**Ann Machado - 20 Fairview St. - Permit #2013-02262 - replace front porch & retaining wall**

**From:** Ann Machado  
**To:** vailprops@gmail.com  
**Date:** 10/9/2013 1:50 PM  
**Subject:** 20 Fairview St. - Permit #2013-02262 - replace front porch & retaining wall

EXISTING CONDITIONS PLAN OF 20 FAIRVIEW STREET PORTLAND MAINE

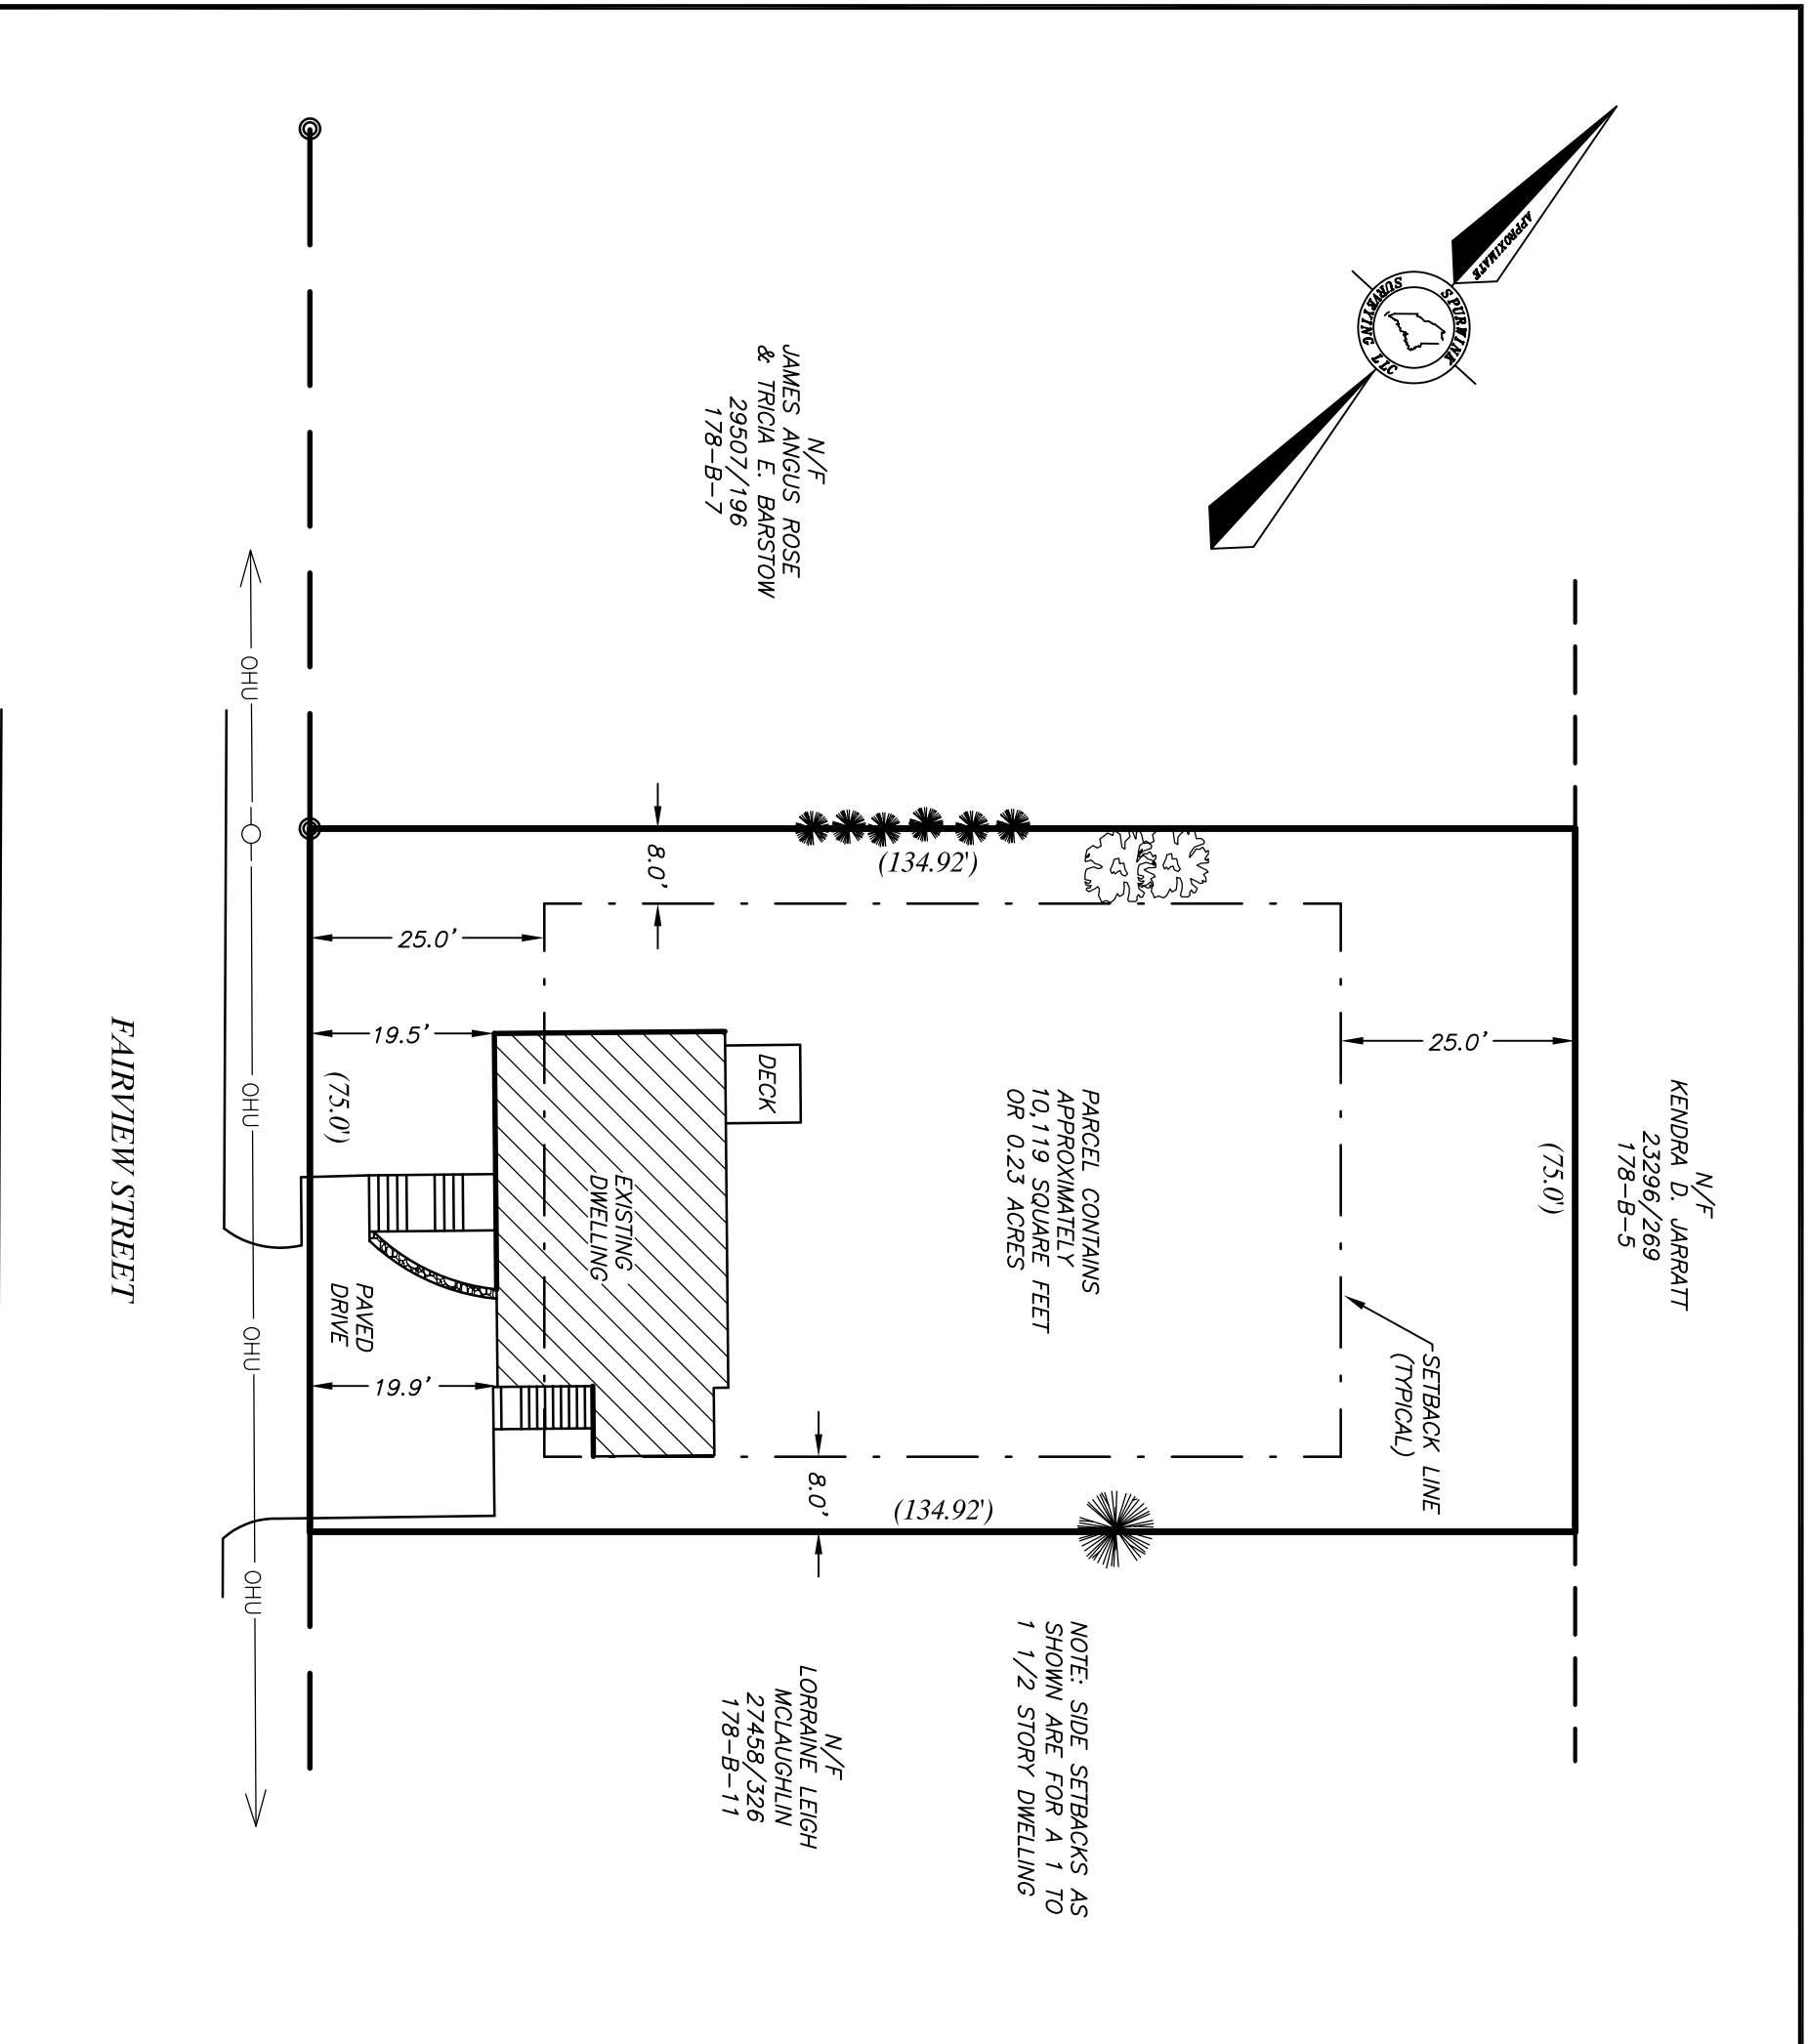
I have done my zoning review and at this point I can't sign off on the permit. You provided a plot plan for the existing conditions. You also need to provide a plot plan for the proposed conditions which shows the setbacks for the enlarged front porch. The setback for the front yard is 25' or the average of the front yard of the properties on either side. The existing plot plan shows the setback to the house at 19.5'. The proposed new porch is larger than the existing, so it needs to meet the 25' front setback or the average.

Please either submit a plan that shows the existing front yards of the properties on either side to determine the average and show that the proposed porch meets this setback (to the bottom of the proposed stairs off the landing) or revise your plan to meet the required setbacks.
